BCA ASSESSMENT REPORT

PROJECT: COLES EXTENSION

ADDRESS: M7 BUSINESS HUB OLD
WALLGROVE ROAD, EASTERN CREEK

Date: 11 February 2013

A DOCK OFFICE PLAN
- CDC EXPANSION

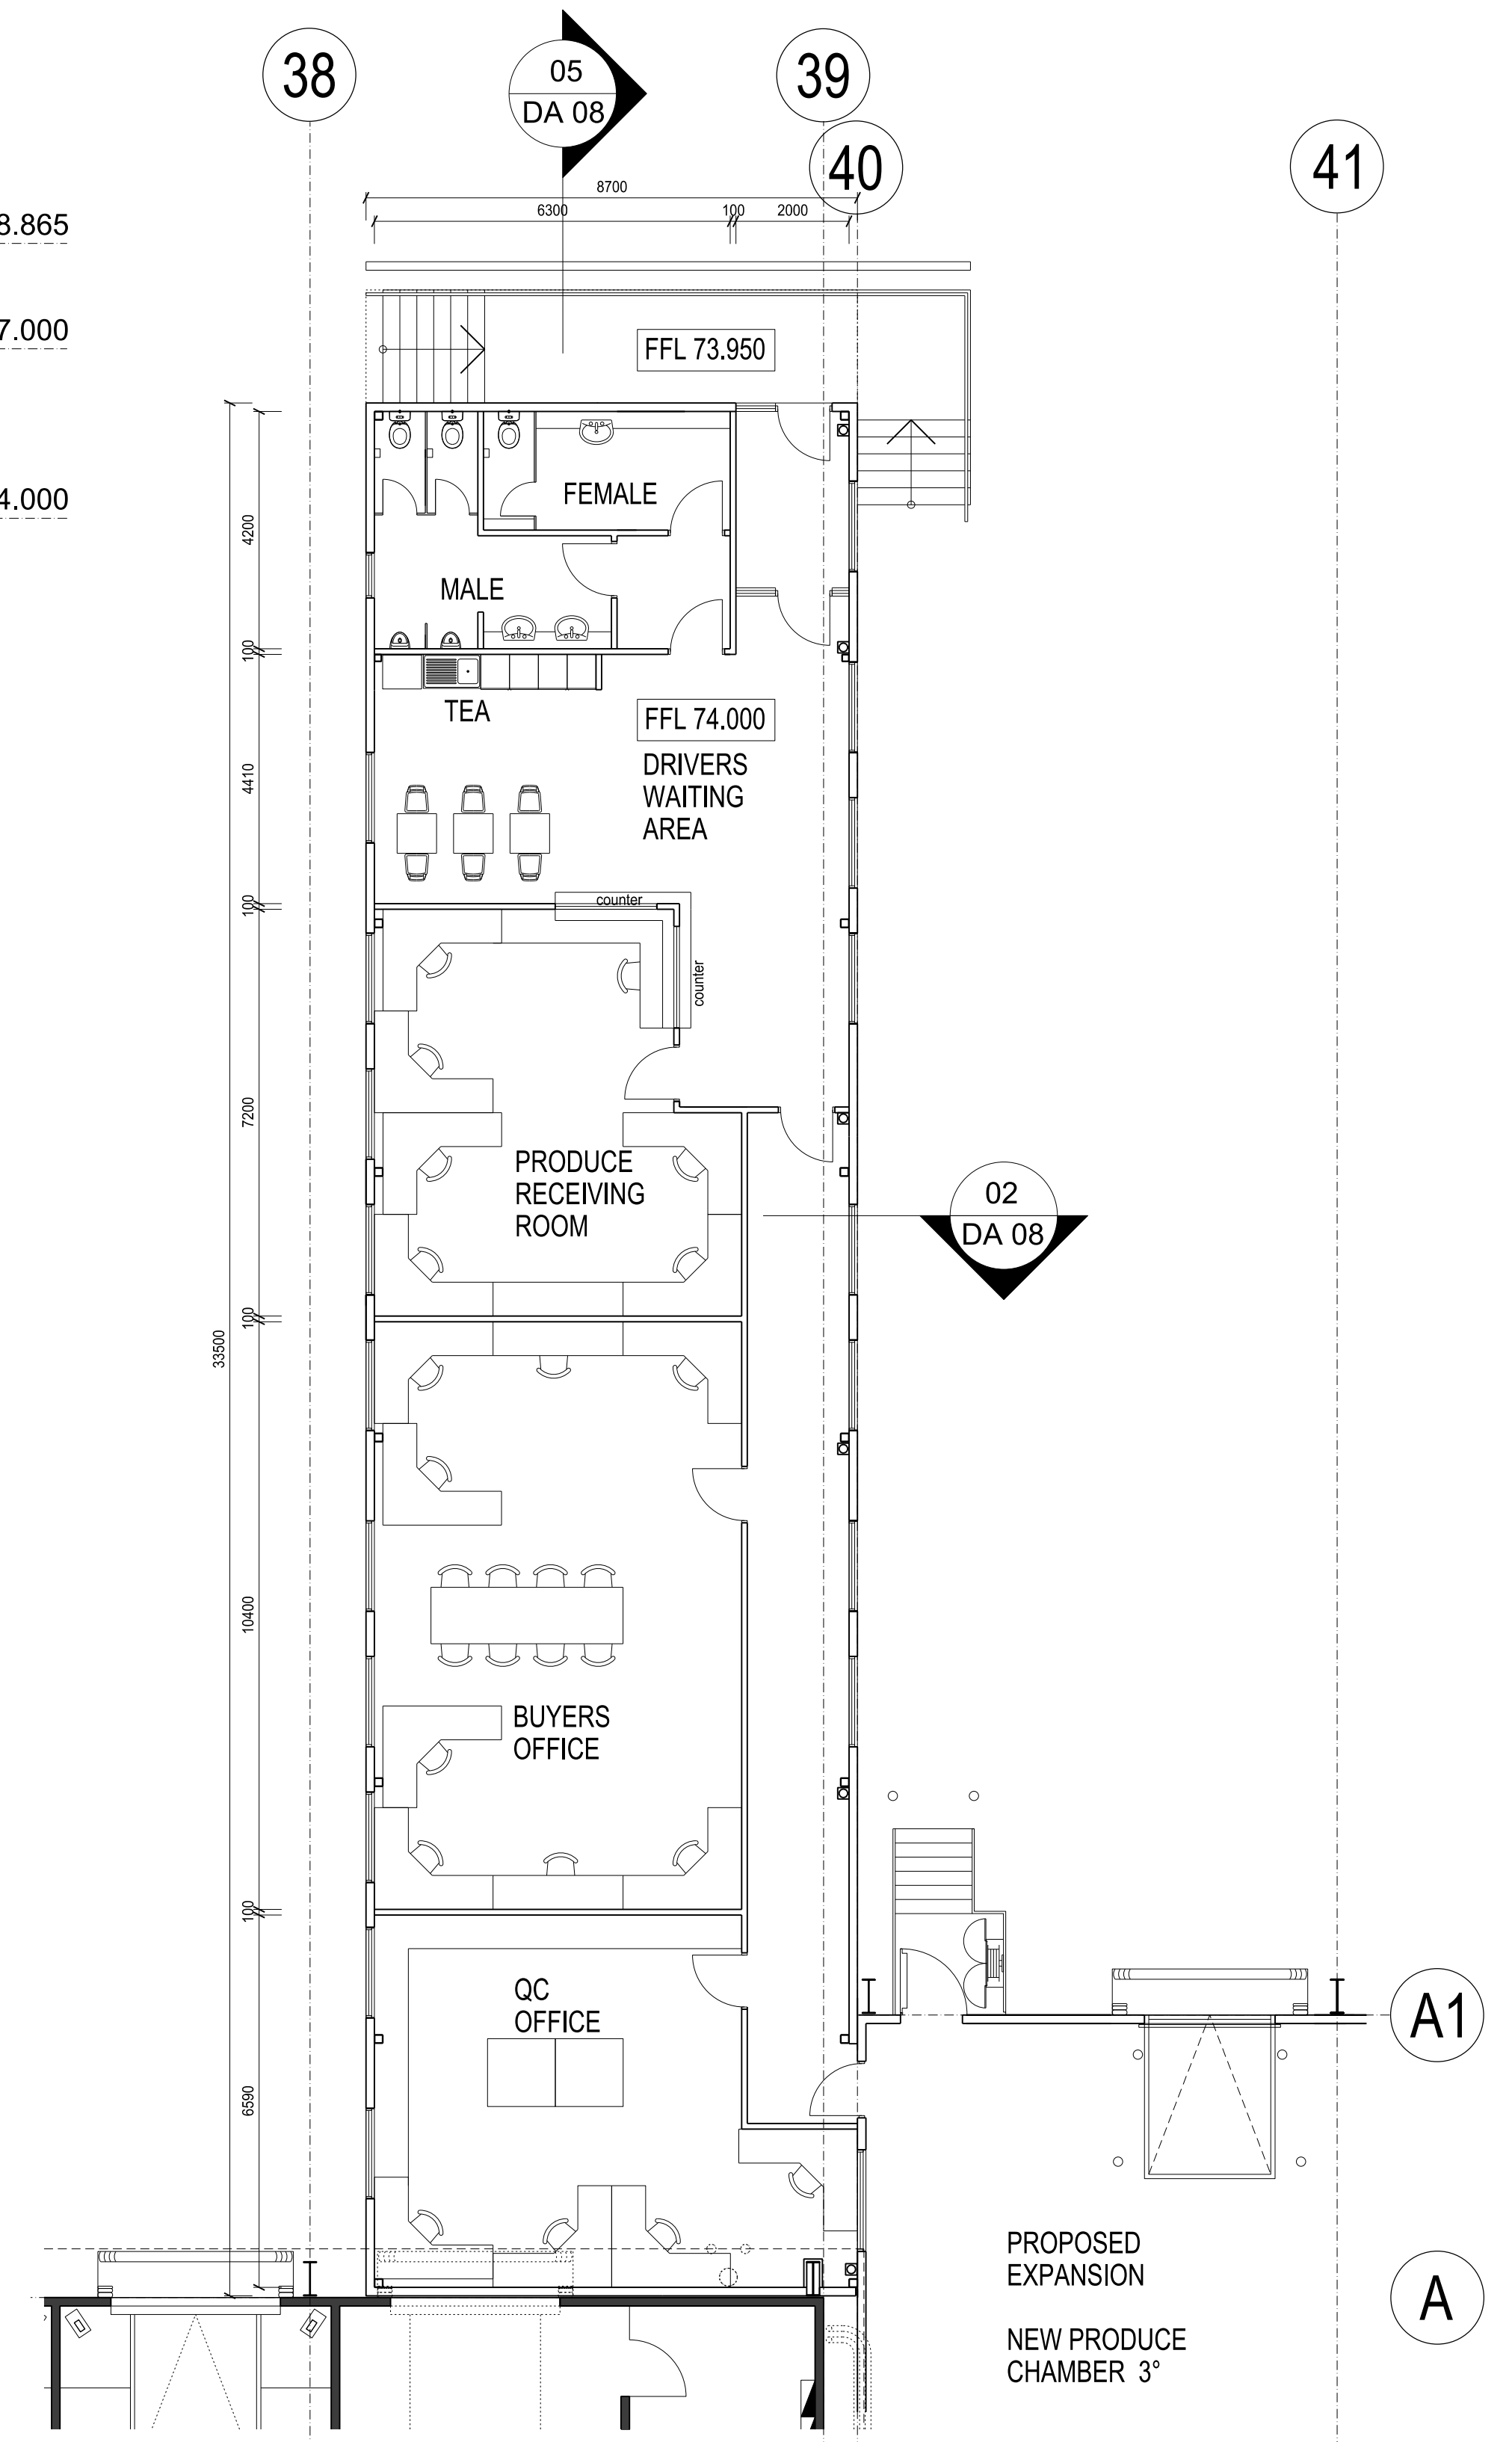
Comments: This requirement applies in relation to the new dock offices if any electrical distribution boards or Comms. equipment are to be installed.
